**Re: Objection to MP08_0244 MOD 1 Modification Request for Mixed Used Development at 23-37
Lindfield Avenue and 11 Havilah Lane, Lindfield**

As a resident of Lindfield, I/we wish to lodge an objection against the proposed Modification of the subject development based on the following grounds:

1 SHADOW DIAGRAM - 21stDEC_9AM
5003 SCALE1 : 650

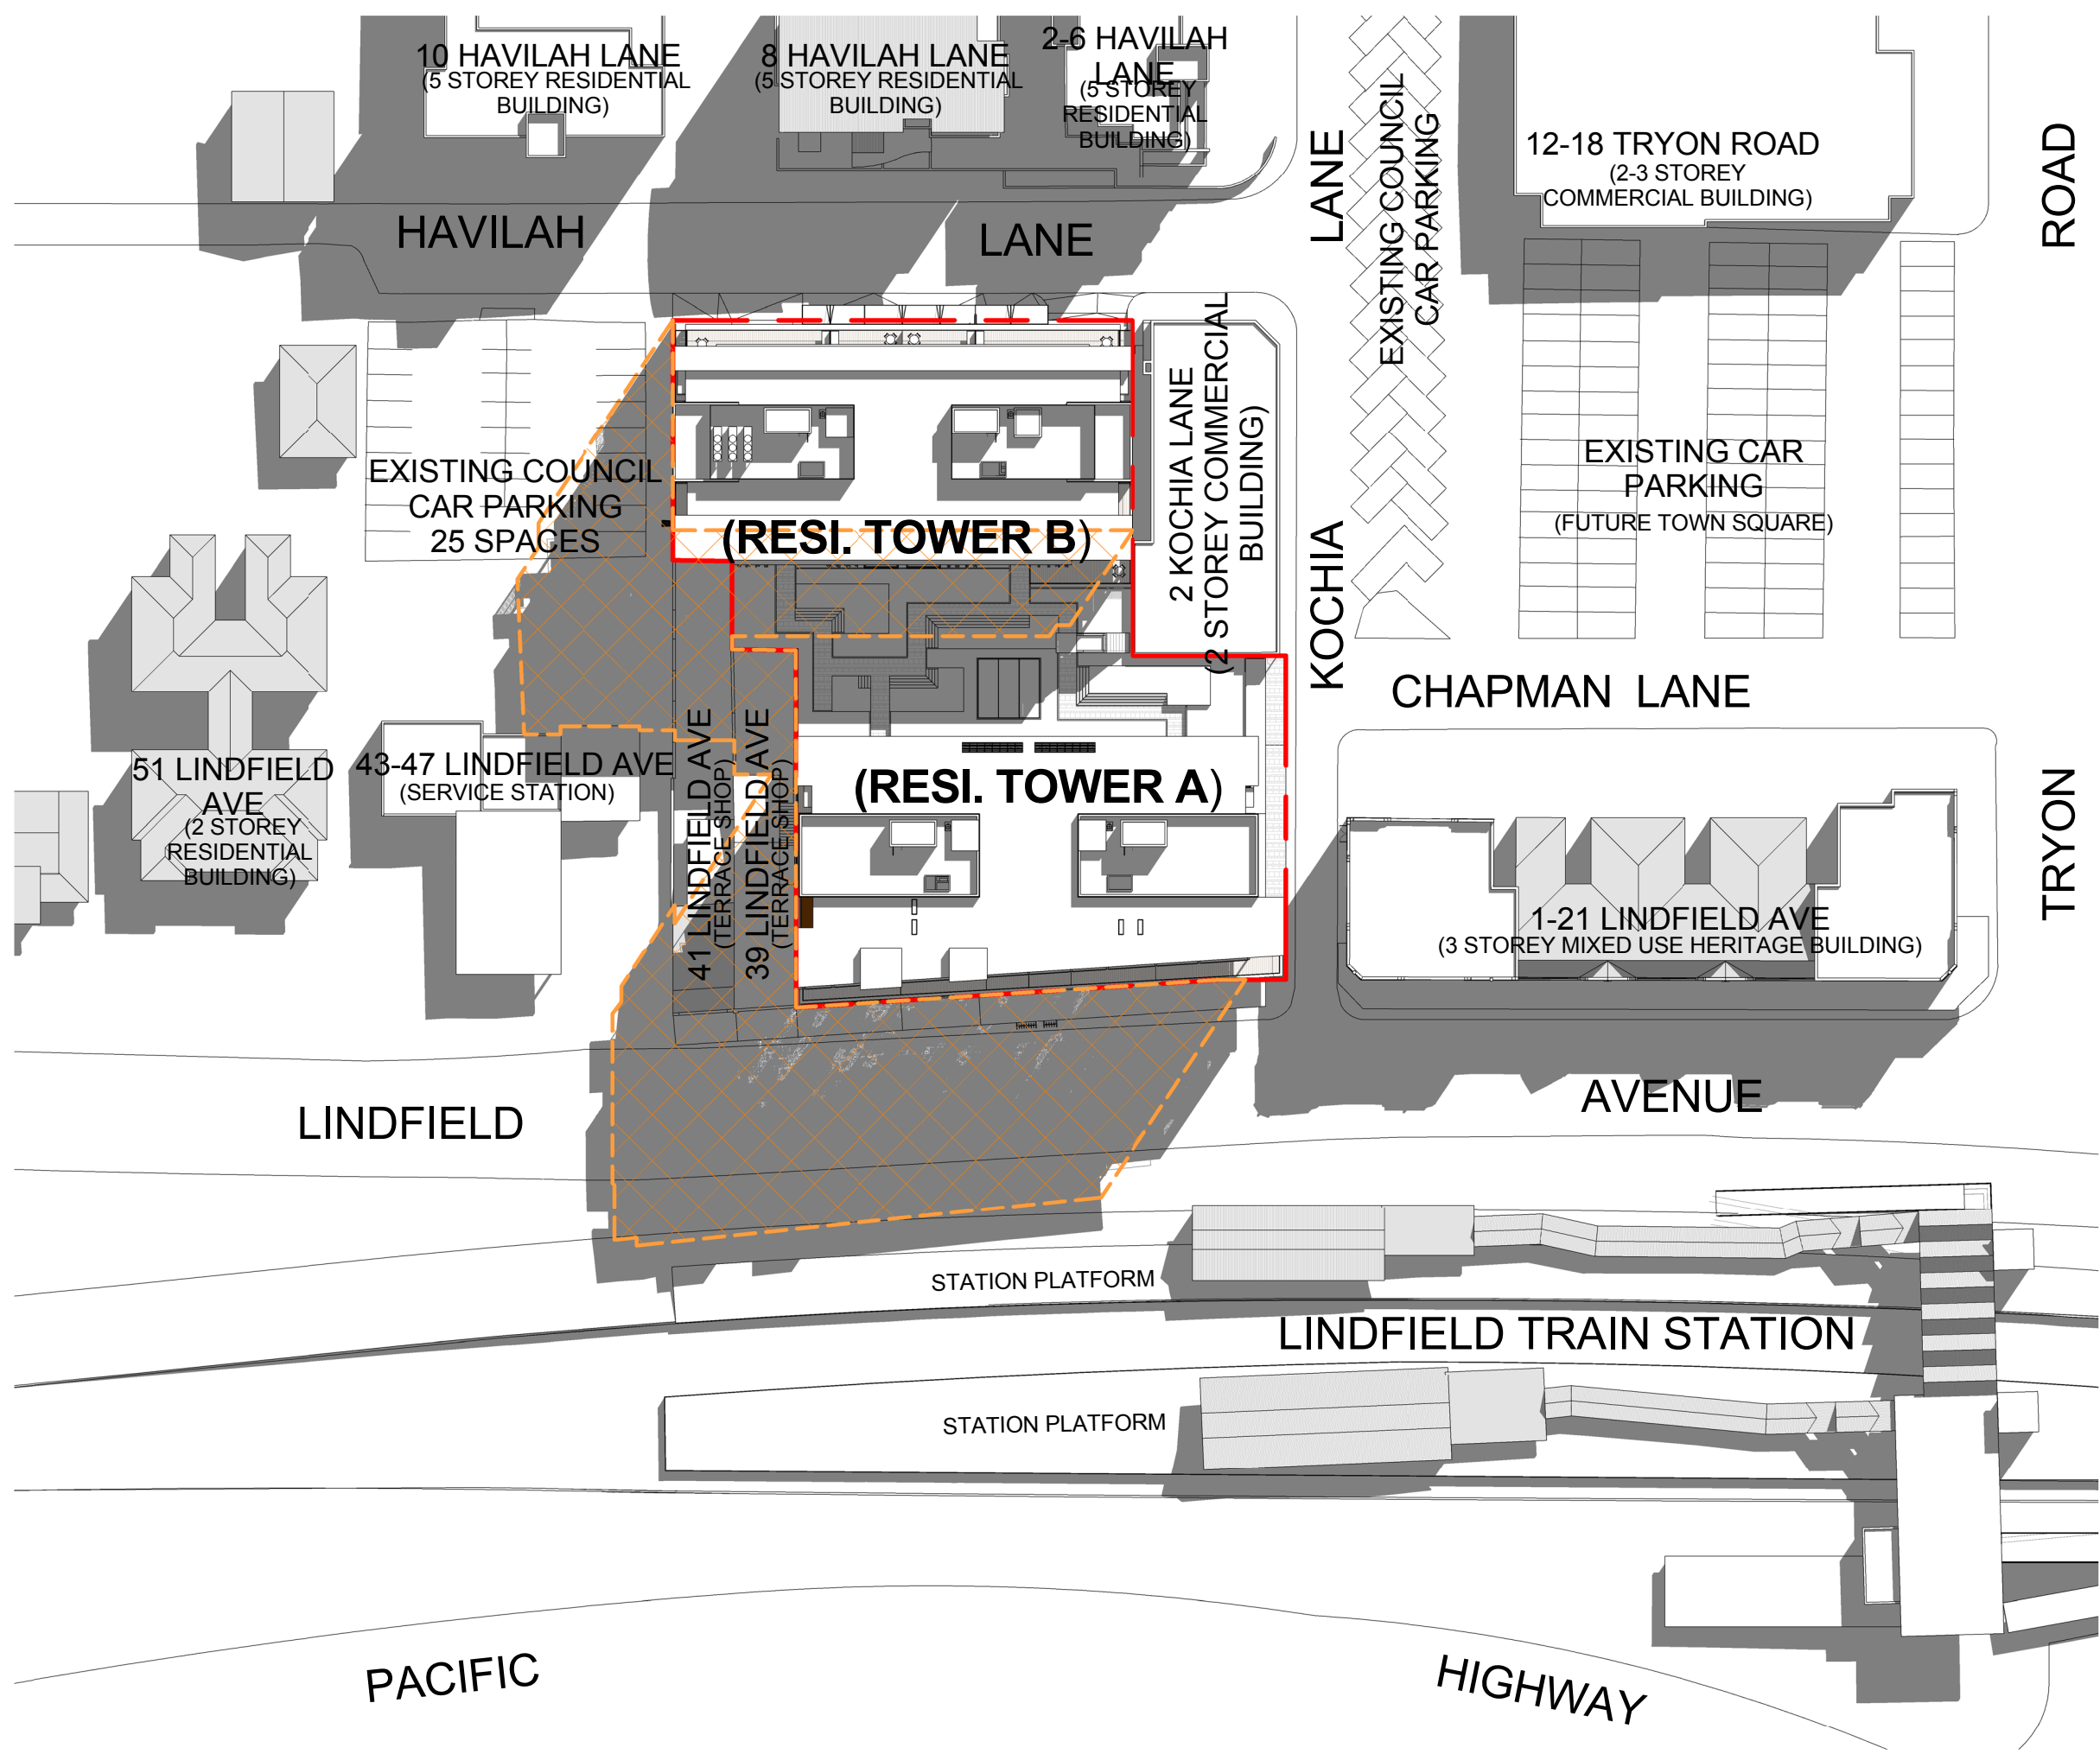
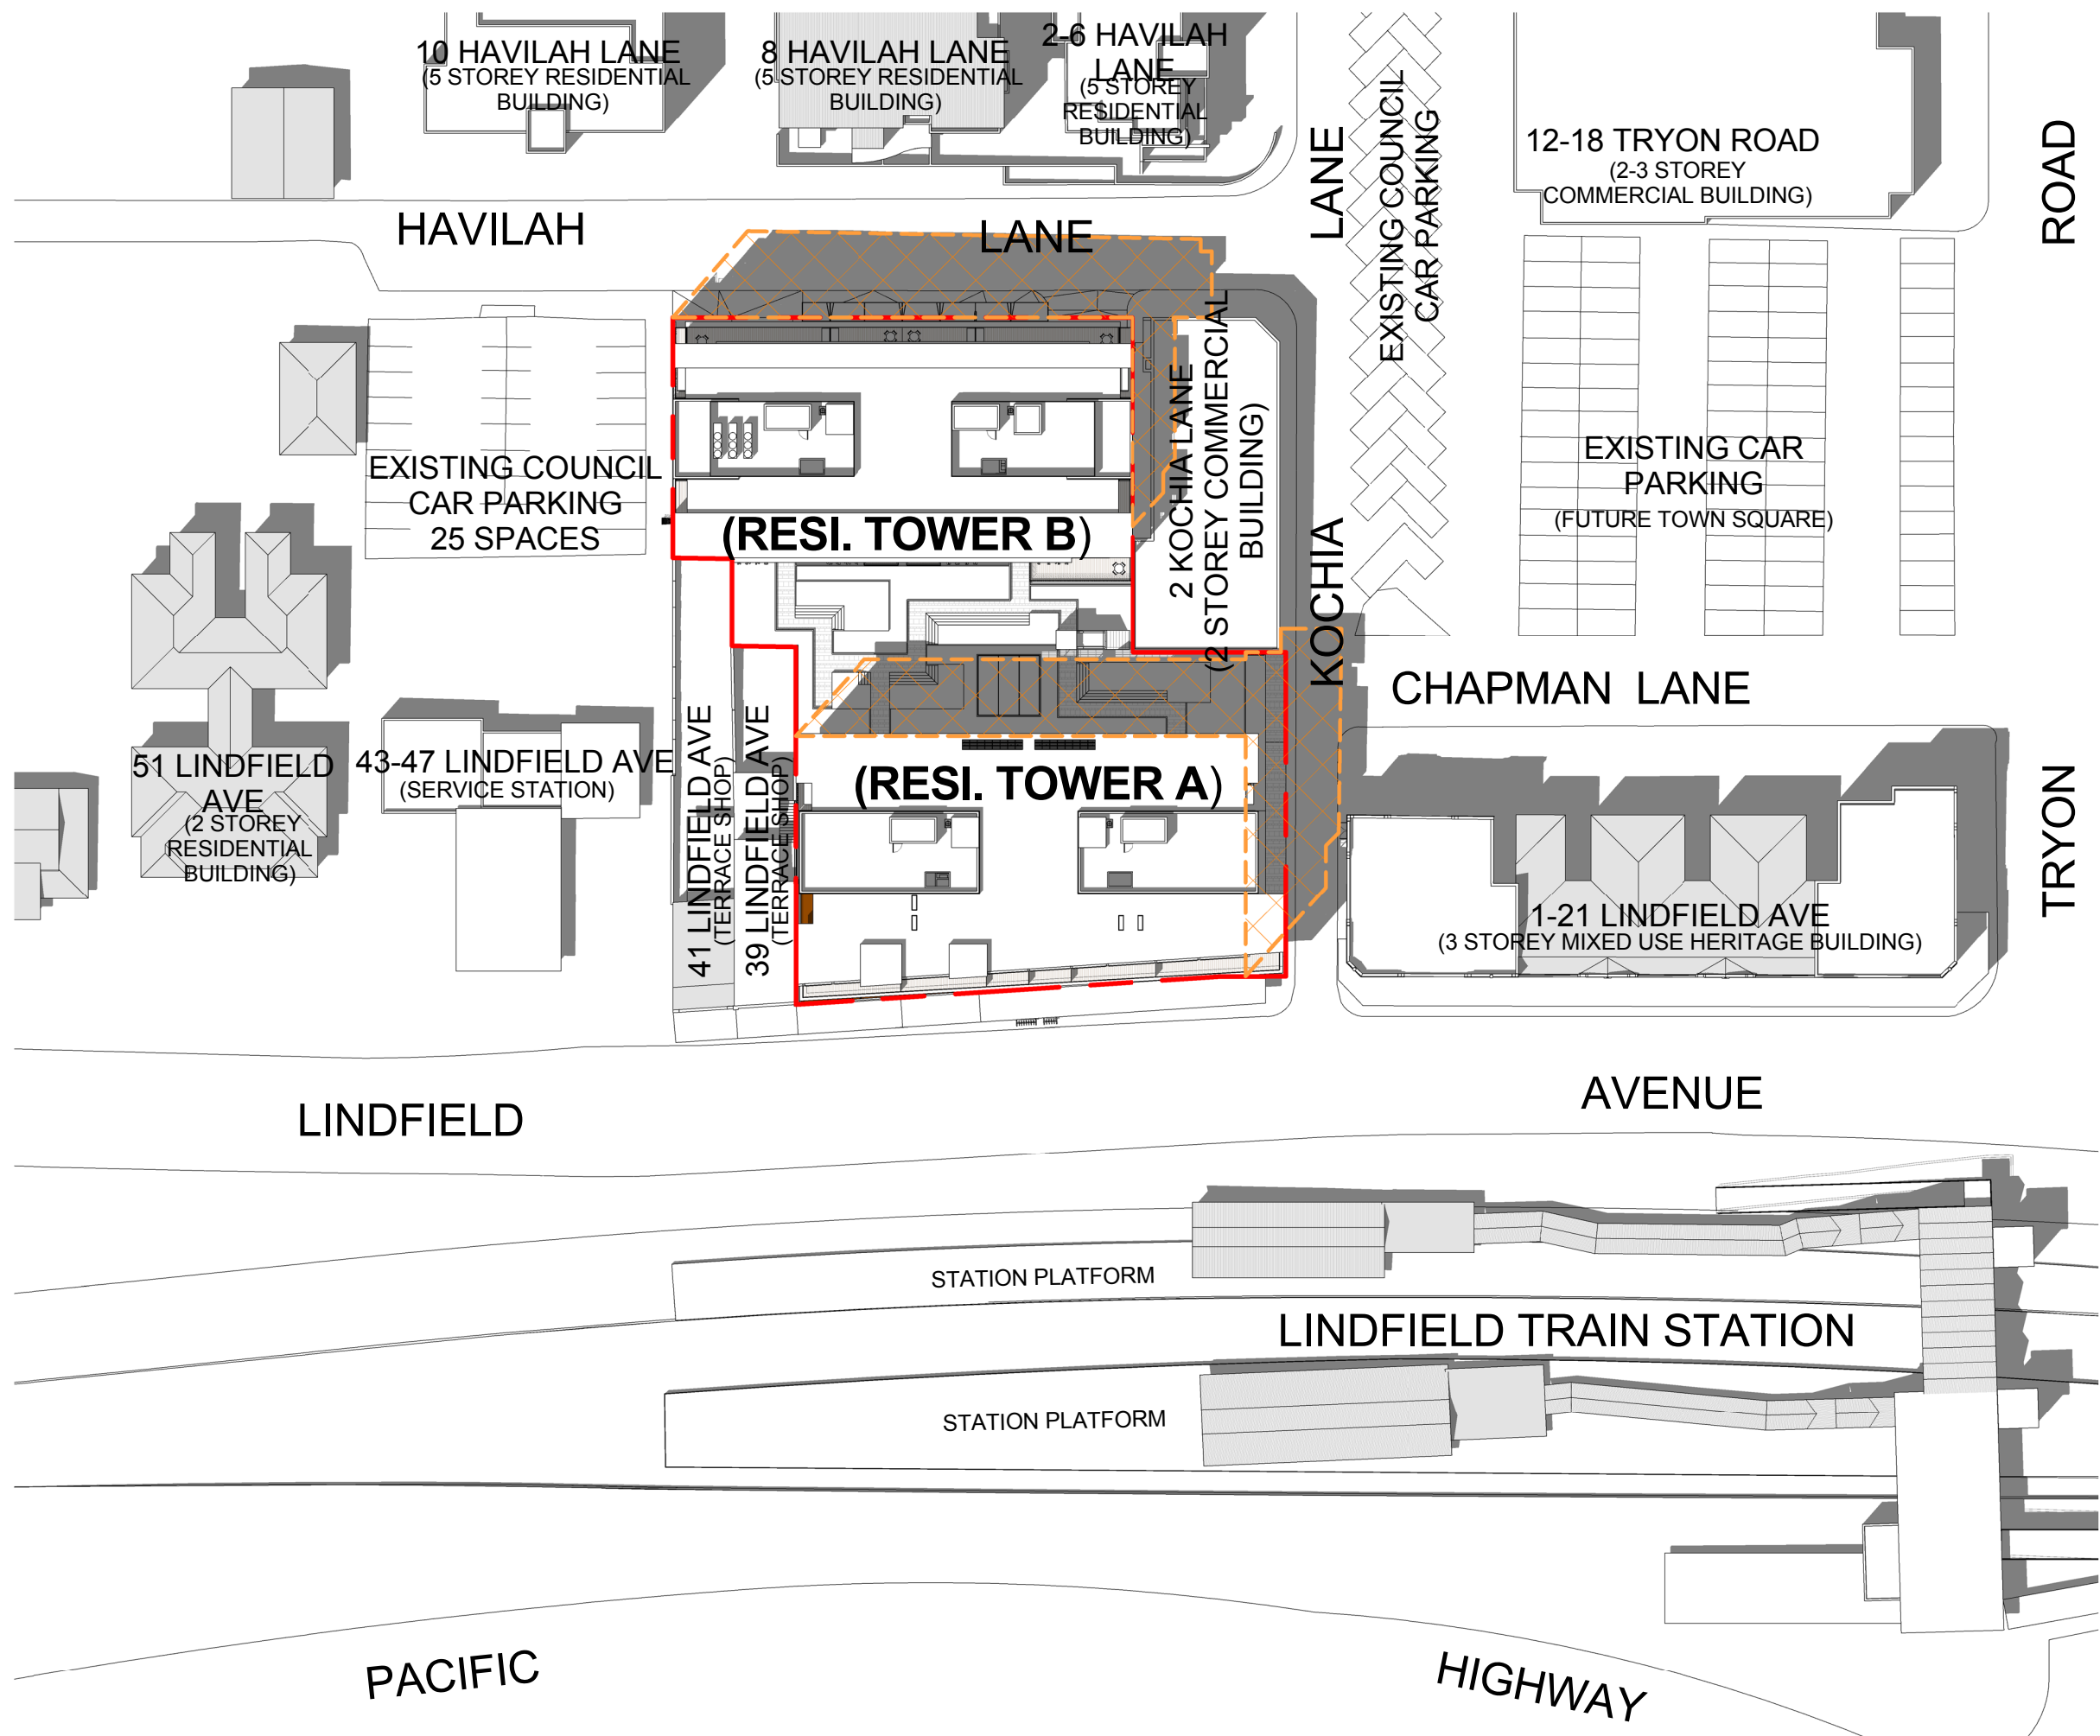
- The additional storeys create new adverse shadowing: a) for residents in the Havilah Lane apartments, particularly after 3pm b) for the popular outdoor café and central Lindfield hub area at 12 Tryon Road in afternoons, particularly in winter and c) for all commuters on the city bound Lindfield rail platform, instead of 50% of the year as approved, it will now be in shadow in the mornings 75% of the year
